<b>Reference No:</b>	2026/70/90162/W
<b>Site Address:</b>	Hinchliffe Mill, Water Street, Holmbridge, Holmfirth, HD9 2NX
<b>Description:</b>	Variation of condition 2 (plans and specifications) of previous permission 2021/90800 for redevelopment and change of use of former mill site to form 19 residential units (within a conservation area)
<b>Recommending Officer:</b>	Victor Grayson

**DECISION – Section 73 Variation of Condition – Approve**

## Officer Report

Drawn DRH
Date June 2025
Scales 1:100 @ A2
Drawing No. 2559 - 0304 - P03

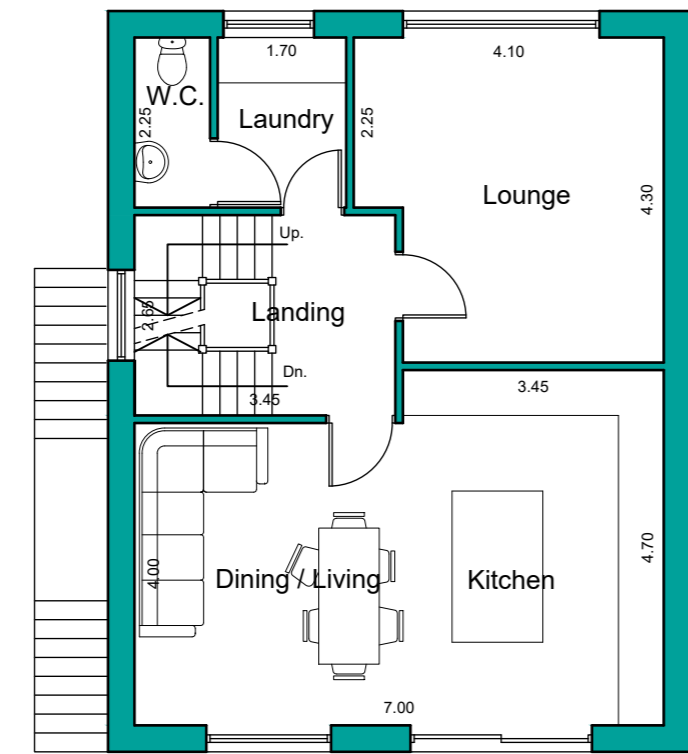
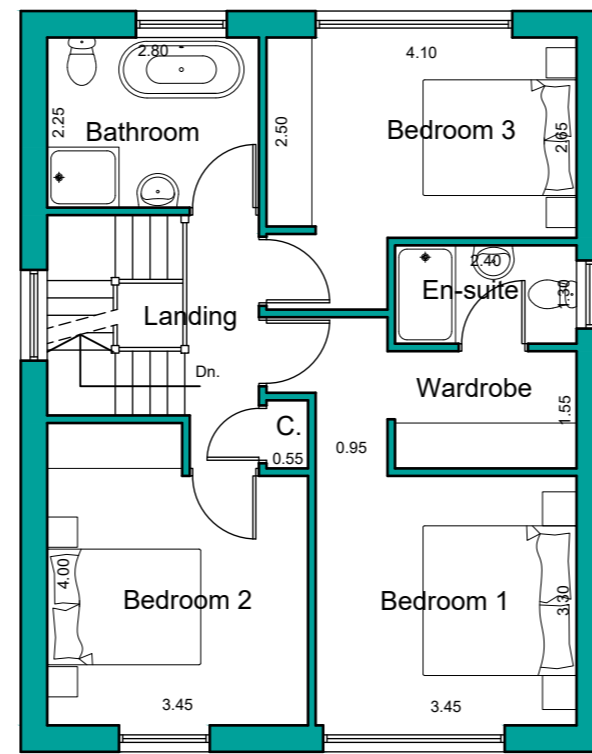
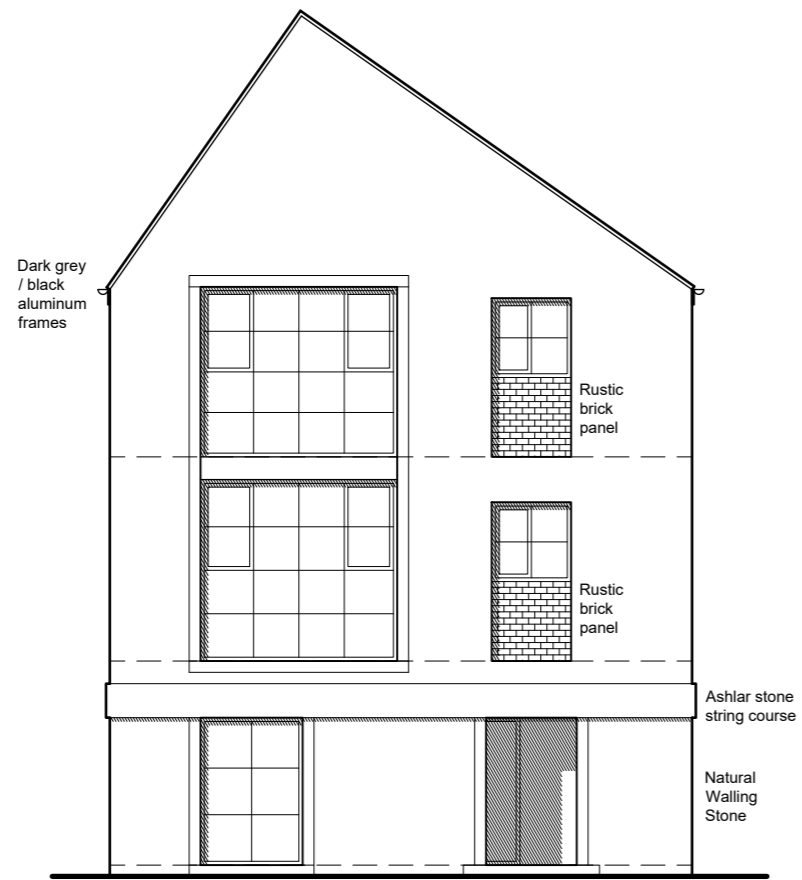
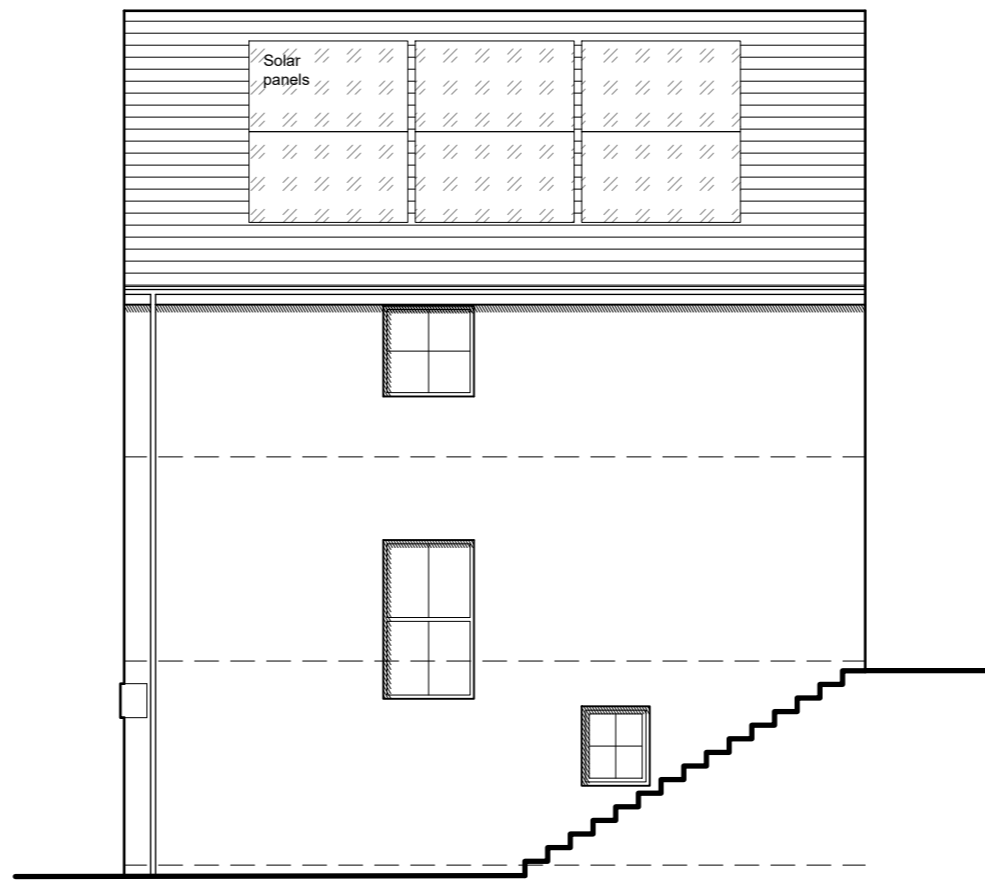
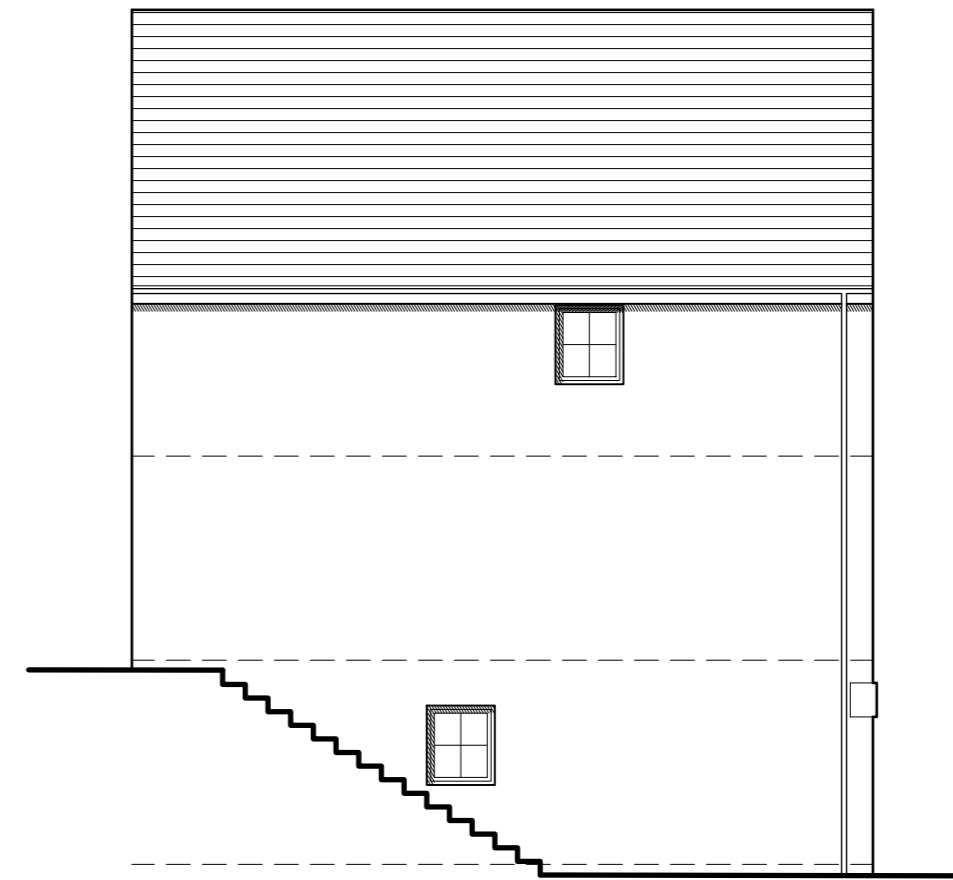
Approved drawing 3372 (0-) 403 rev E showed one house type for units 10, 11, 12, 13, 14 and 15, while approved drawing 3372 (0-) 404 rev D showed a similar (but slightly different) house type for unit 16. In the current submission, the applicant proposes a house type A for units 12 and 14 (illustrated in drawing 2559-0304 rev P03), house type B for units 10, 11 and 13 (illustrated in drawing 2559-0305 rev P04), and house type C for units 15 and 16 (illustrated in drawing 2559-0306 rev P04). Again, there is a great deal of similarity between the house types proposed within this group of seven dwellings.

Regarding the proposed changes, the loss of the previously-approved projecting/cantilevered elements is regrettable in some respects, as it would reduce the elevational relief and visual interest of the elevations. However, the simplified elevations now proposed are still considered appropriate for this site and its context, and approval of them would have been recommended had they been proposed under application 2021/90800.

The proposed introduction of “rustic brick” panels to some of the window apertures (in house types A and B) is considered acceptable in principle (of note, a similar design feature has been included in two major developments on Manchester Road), subject to the proposed materials being considered at conditions stage.

The other fenestration changes to units 10 to 16, the introduction of an ashlar stone string course, and the proposed replacement of recessed external porches with internal entrance lobbies are considered acceptable in aesthetic terms.

The expanded footprints and floorplates of units 10 to 16 (partly achieved by what the submitted Planning Statement refers to as “single storey flat roof extensions”) raise no concerns, nor do the proposed amendments to the internal layouts of these units.

For units 10 to 16, new materials would be introduced under the current application, namely black standing seam profile cladding (to the above-mentioned extensions) and a corrugated black roofing material (for the garages). Materials coloured black have previously been proposed elsewhere in the development, and this colour is generally considered acceptable for this
